**Consultation Response from KC,
Highways Development Management**
2020/94256 Highfield House, Clough Road, Flockton, Huddersfield, WF4 4AQ
Conversion of barn and single storey extension to create one dwelling
**Date Responded:
04/02/201**
**Responding Officer: Zack
Turner**
Responding Ref: 17-34-2

This application is at Highfield House, Clough Road, Flockton, Huddersfield. The proposal is for the conversion of the barn and single storey extension to create one dwelling.

PROPOSED PLANS 1:100

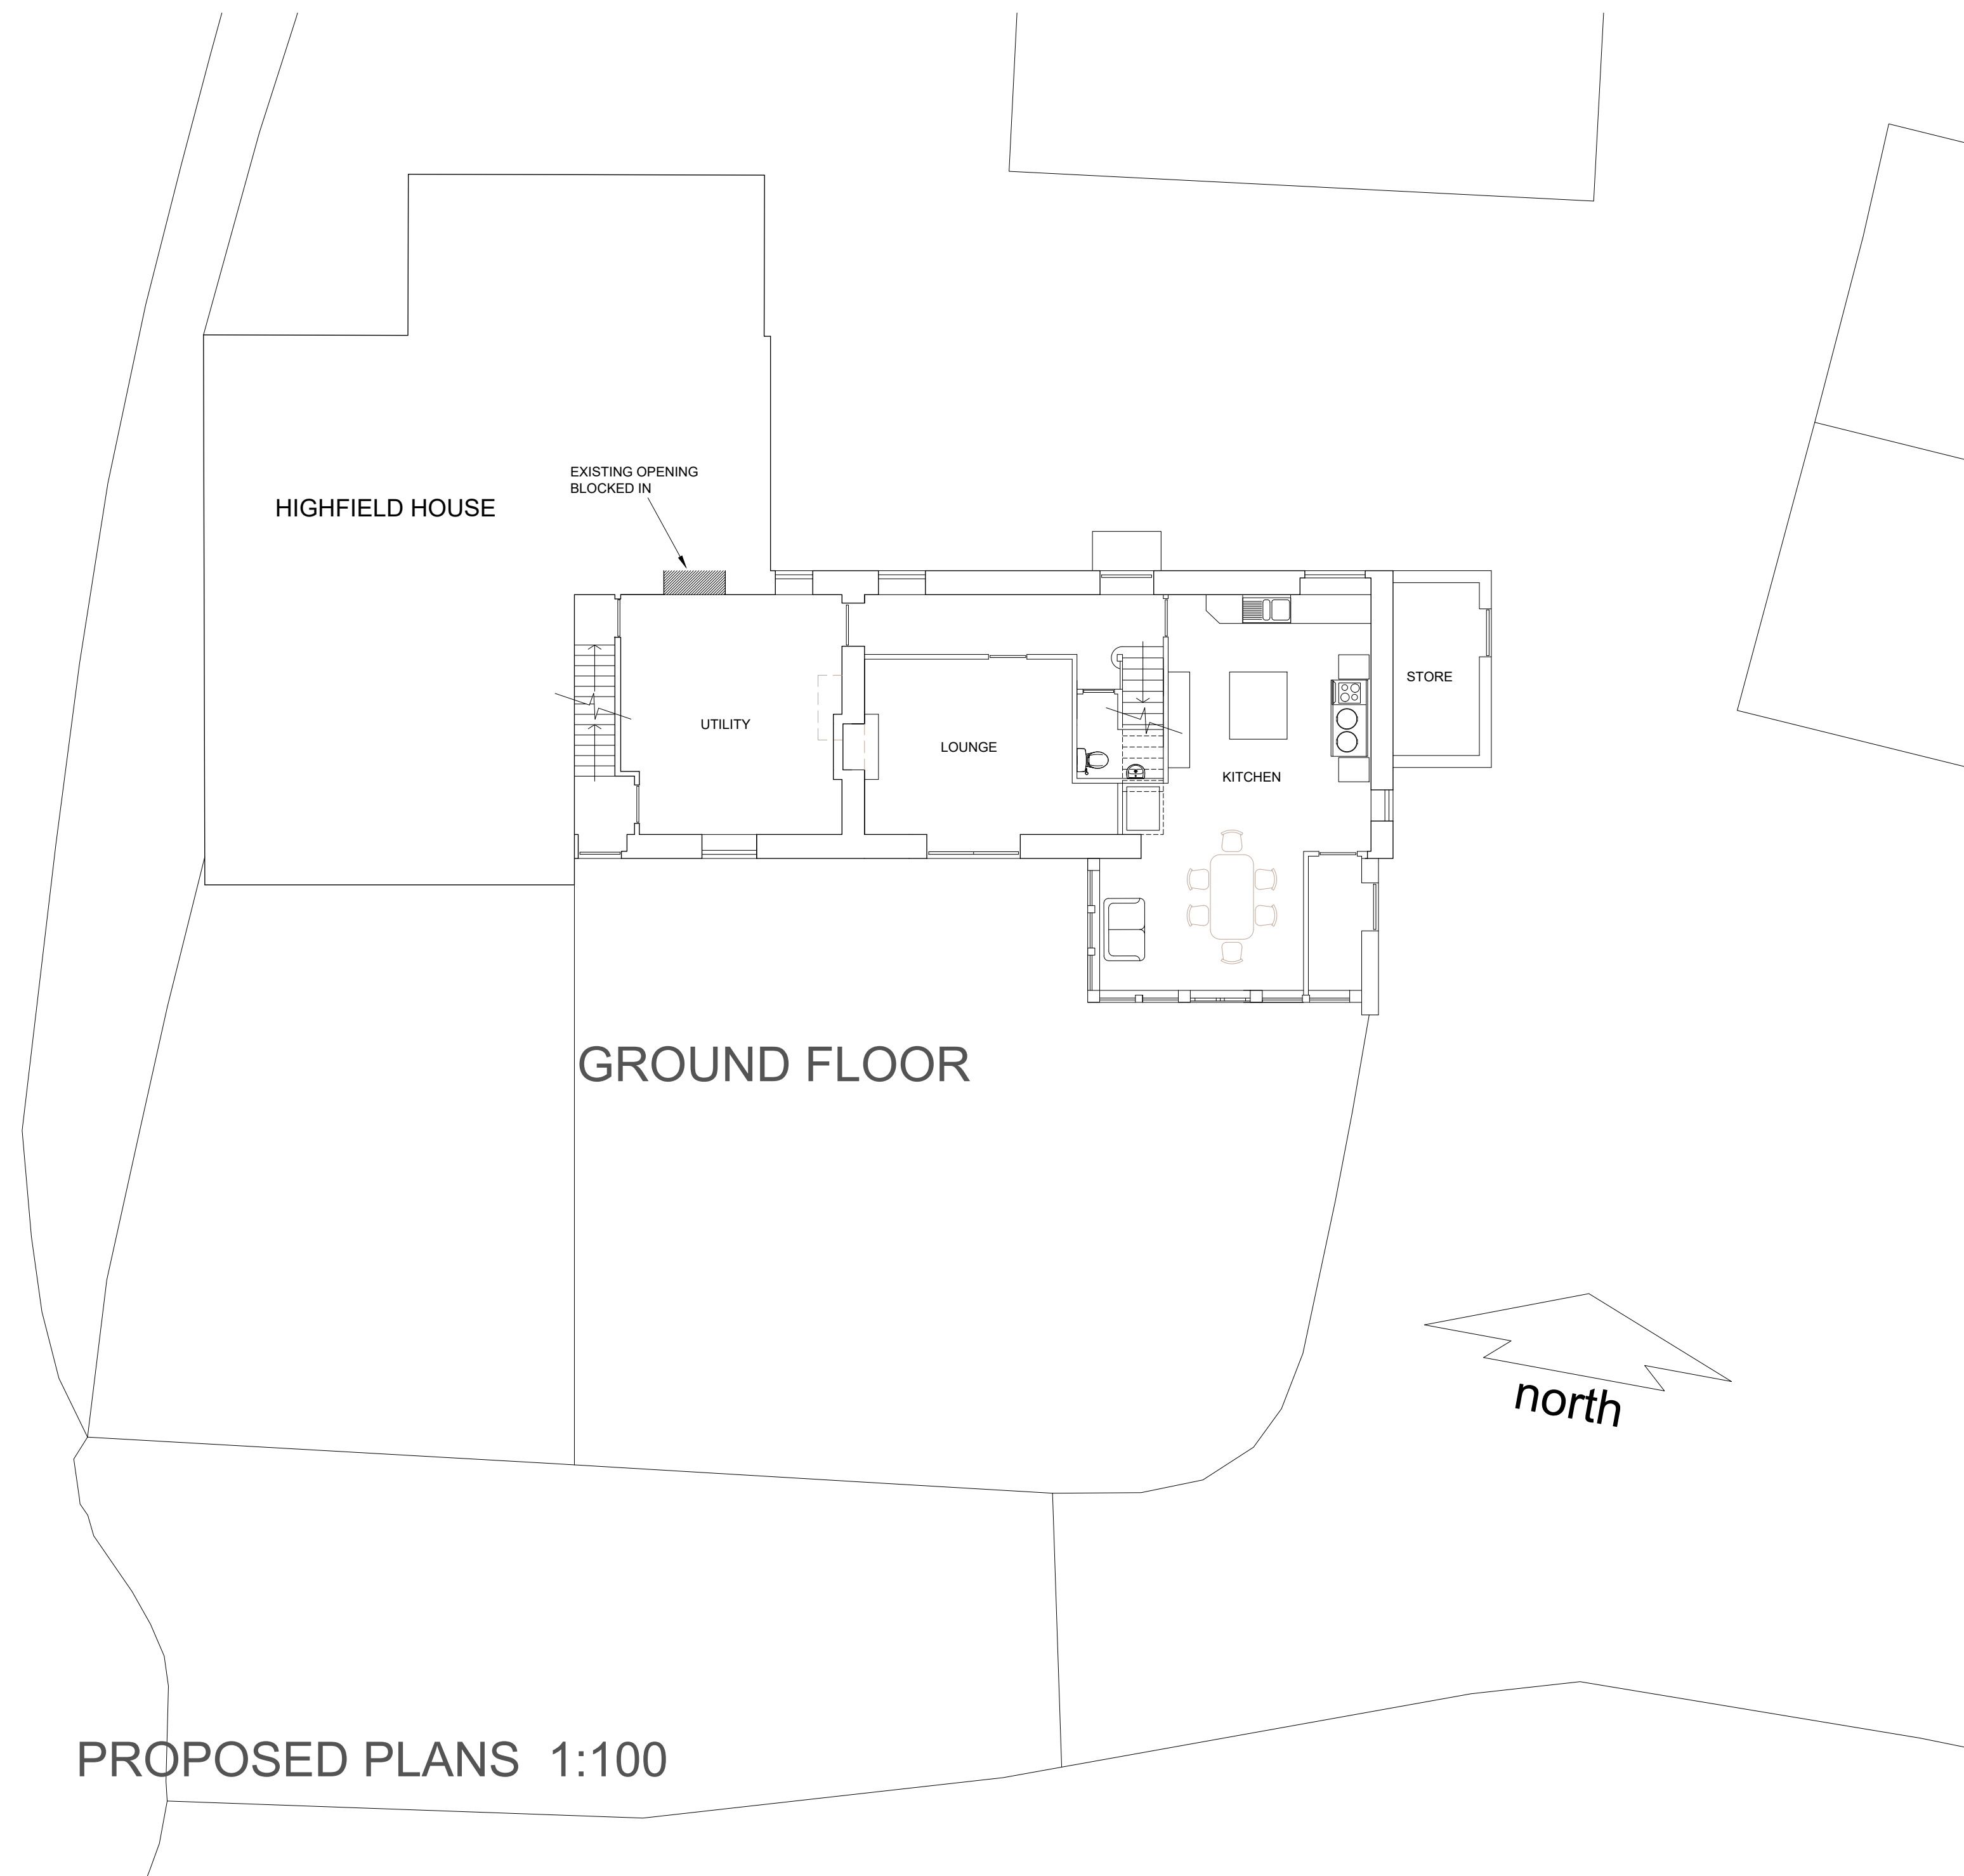
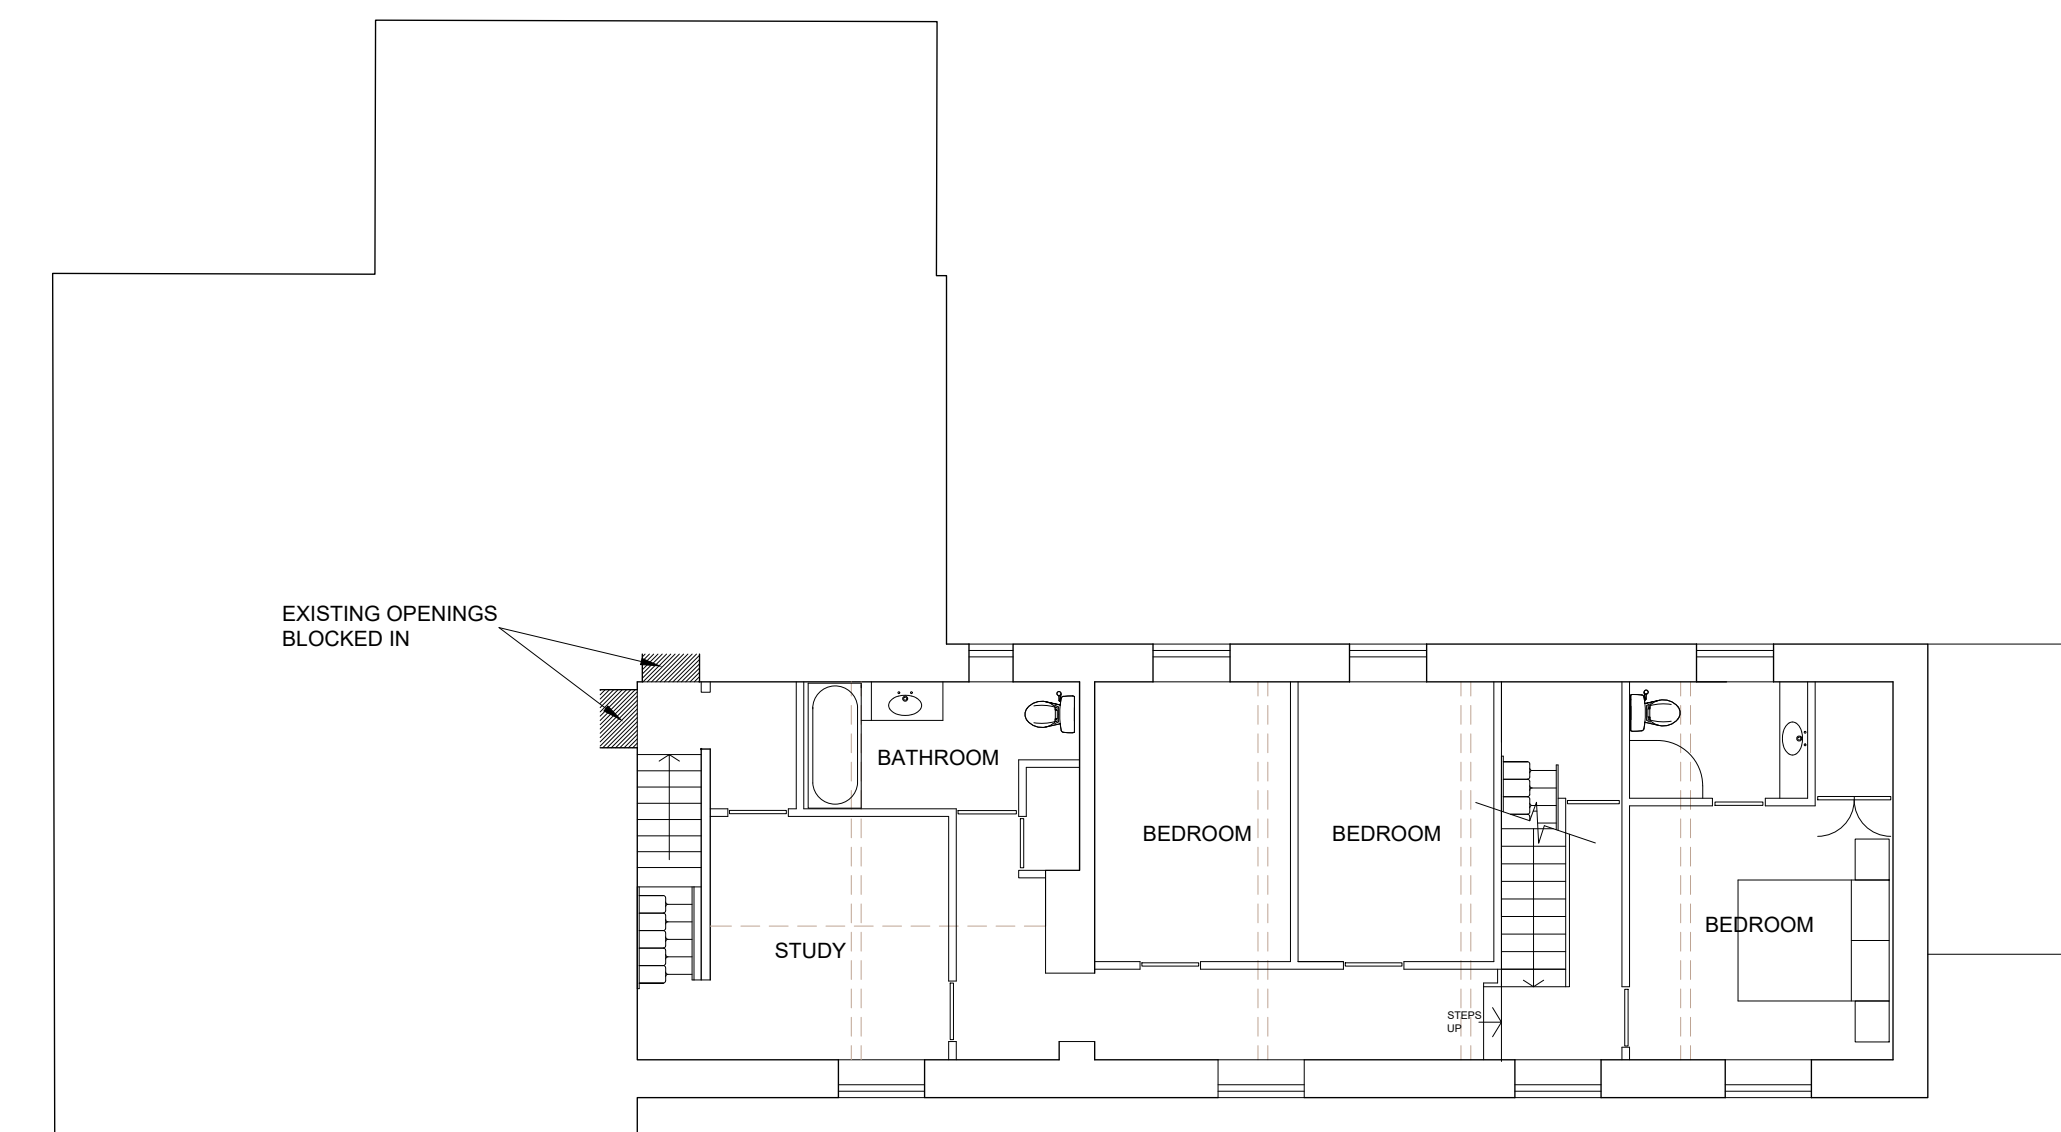
The new dwelling will have 3 bedrooms and in accordance with the Kirklees Highways Design Guide 2-3 bedroom dwellings should provide 2 off-street parking spaces. This is provided by a space either side of the house and this will not implicate previous parking or access arrangements for the existing dwelling.
